Submission ID: 37143

Please find attached comments and views (which the Applicant has failed to supply) relating to the setting of heritage assets in the Central area.

Comments on ExQ1 Responses-Missing Viewpoints and Heritage Assets

Representative Viewpoint 25: View looking south from footpath 238/5/20

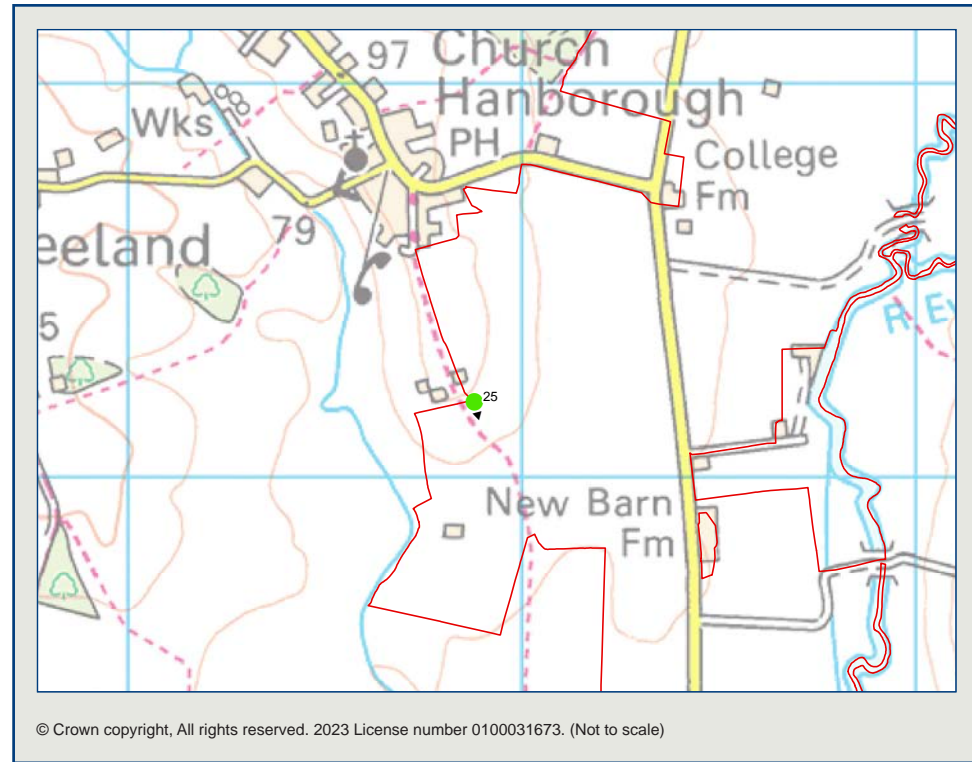
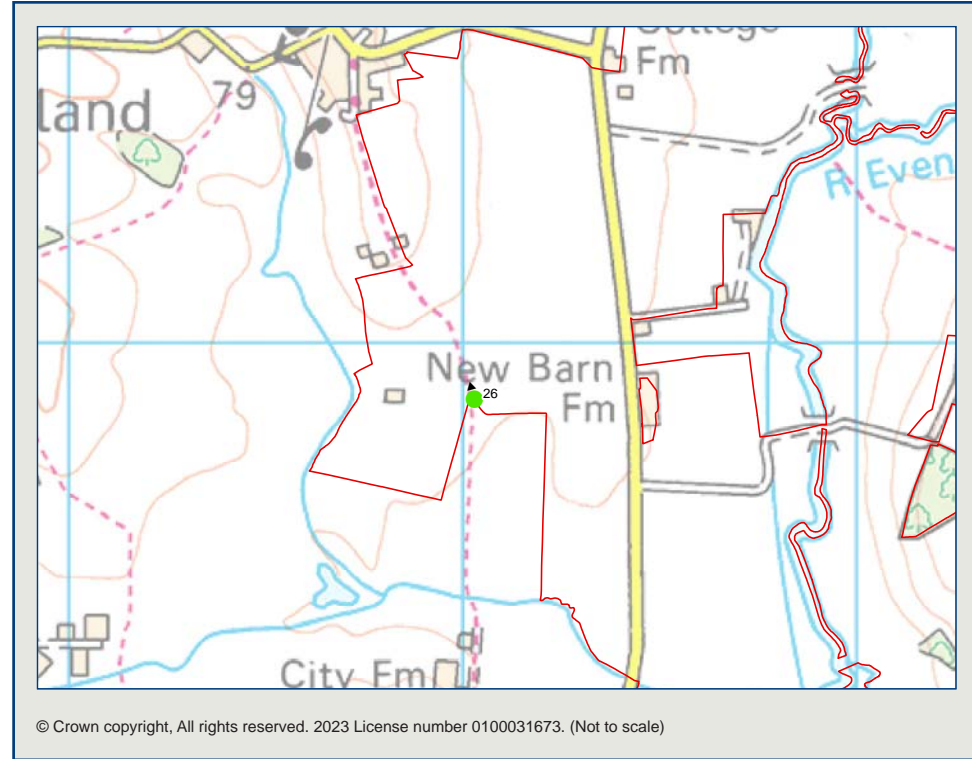
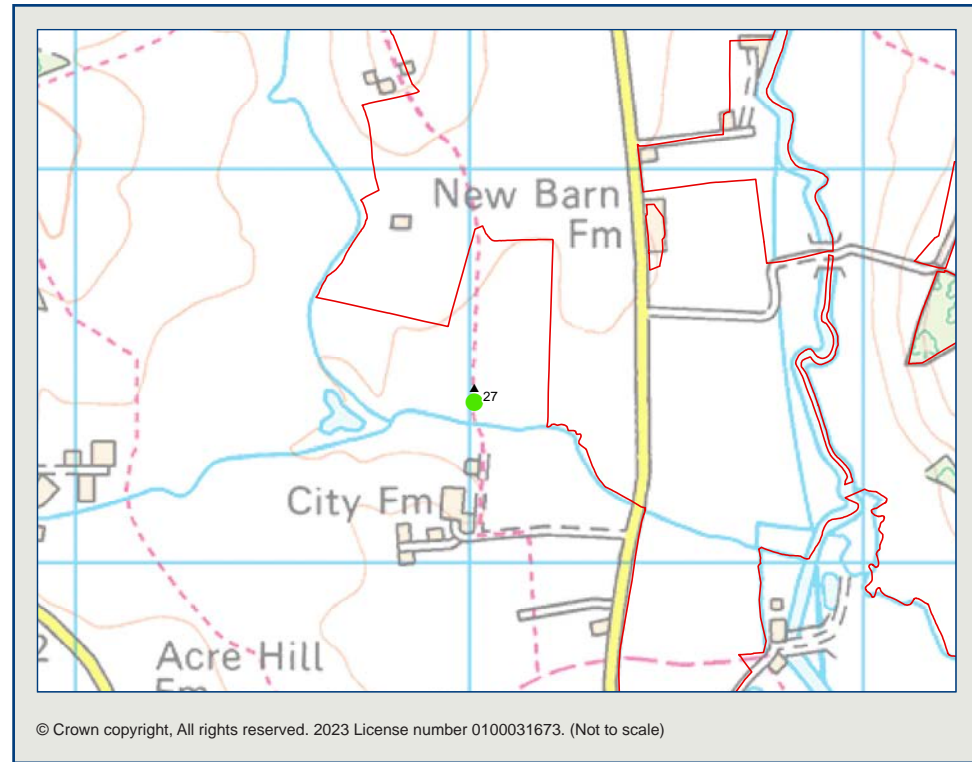
1.2. In fact there are 2 views of St Peter and St Paul. They are #27 which is 1.5km South and #36 which is 2km East.

1.3. The Applicant points out there are 2 viewpoints but fails to answer the question as to why there is no viewpoint nearer than 1.5km.

1.5. View of St Peter and St Paul from PRow 238/5/20 (Eynsham to Church Hanborough) taken looking over panel fields 2.115, 2.118 and 2.120 at a distance of 1.2 km

Representative Viewpoint 37a: View looking east from footpath 152/6/10 at east bank of River Evenlode

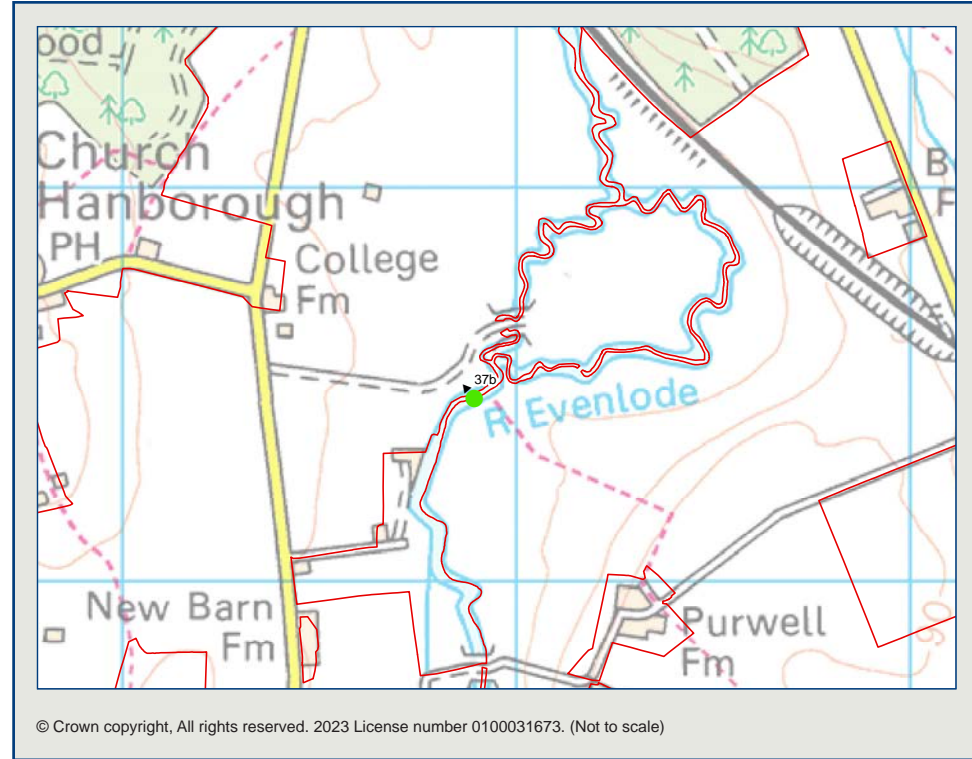
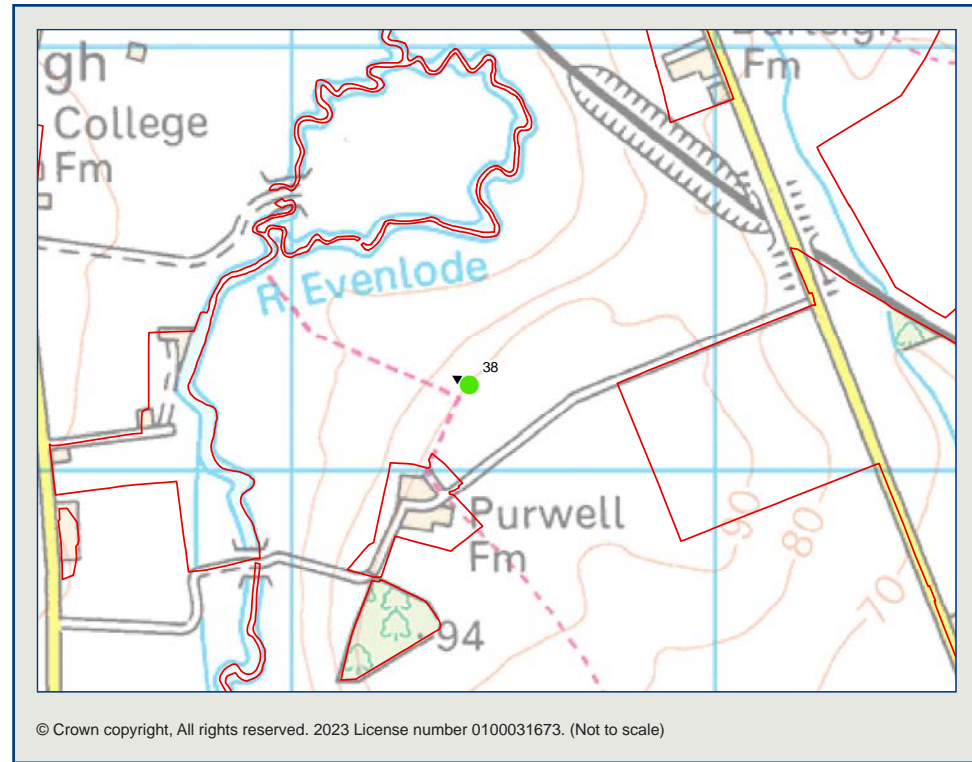
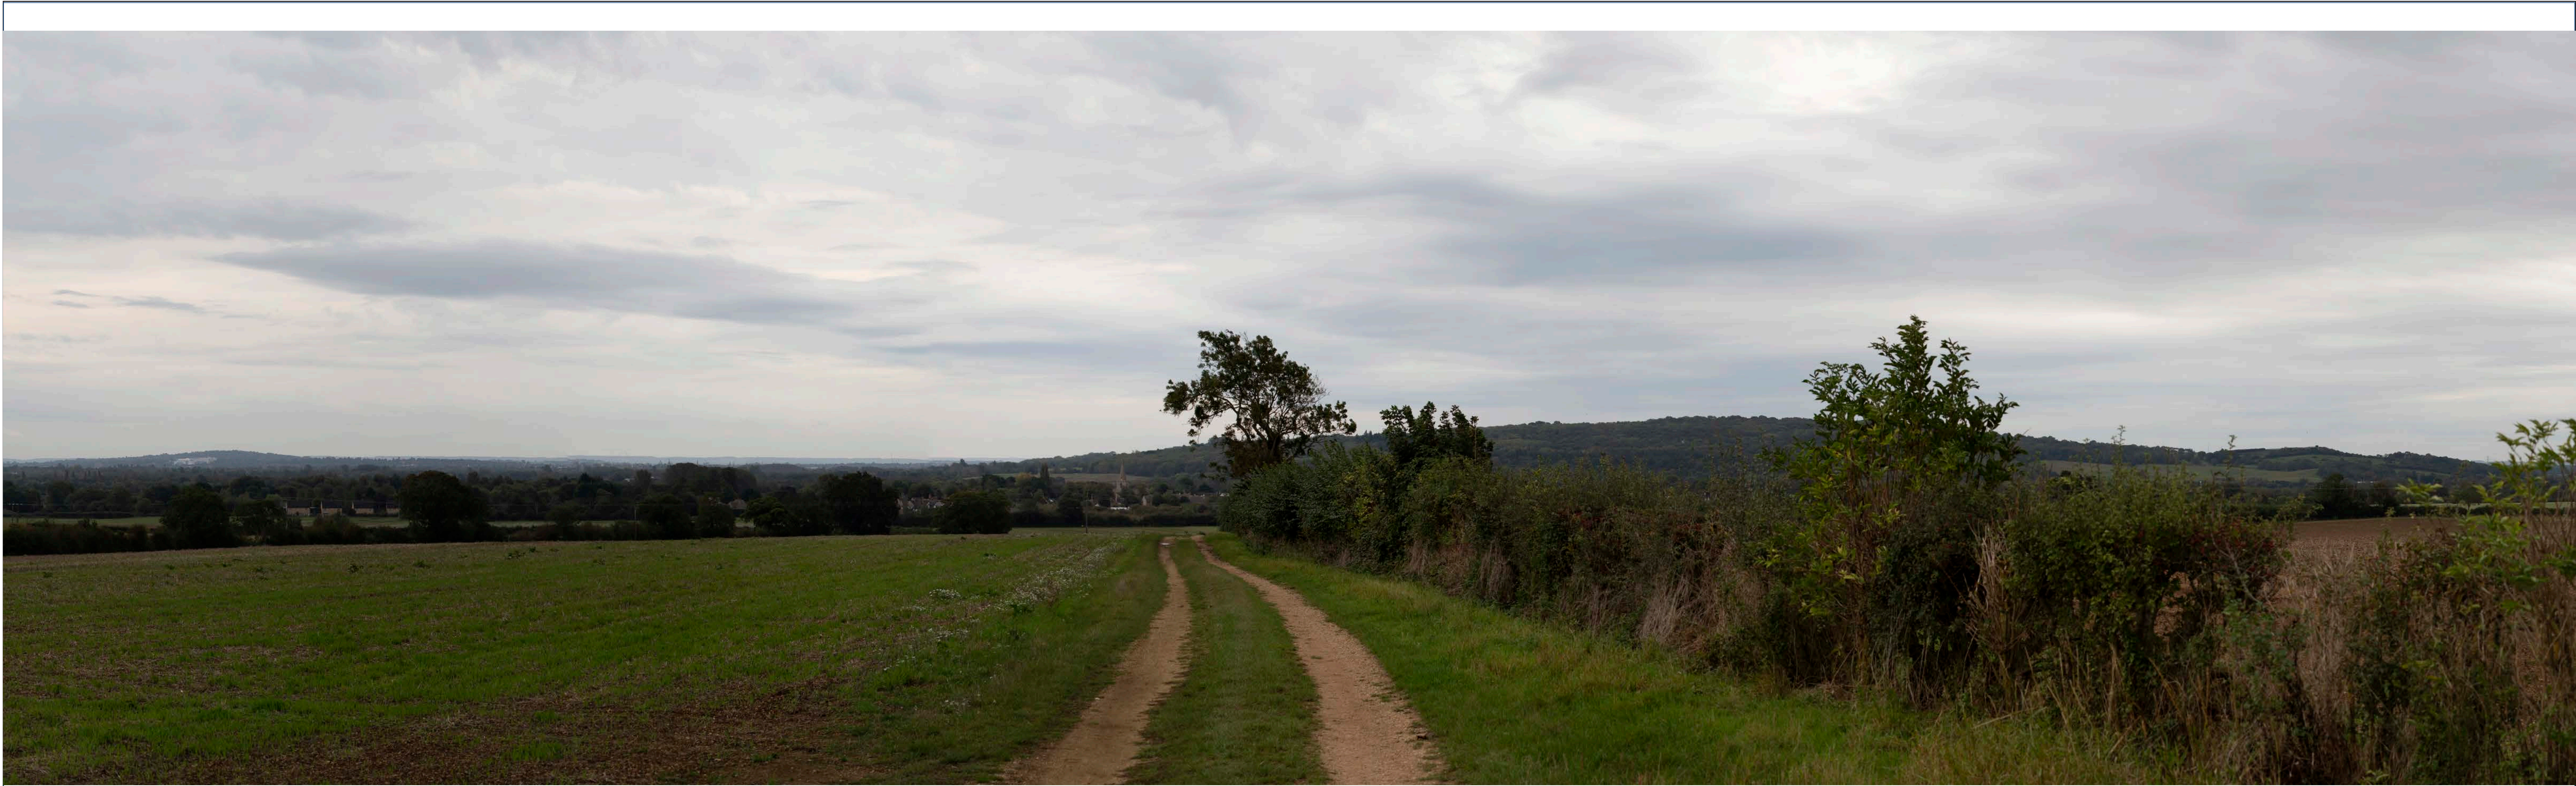
2.3.1. View of St Peter’s, Cassington from PRow 152/6/10 (“The Track”) from Cassington to Purwell Farm looking South East over fields 2.096, 2.102

2.3.2. View of St Peter’s, Cassington from PRow 152/6/10 (“The Track”) from Cassington to Purwell Farm taken looking South over panel fields 2.095, 2.103 and 2.110
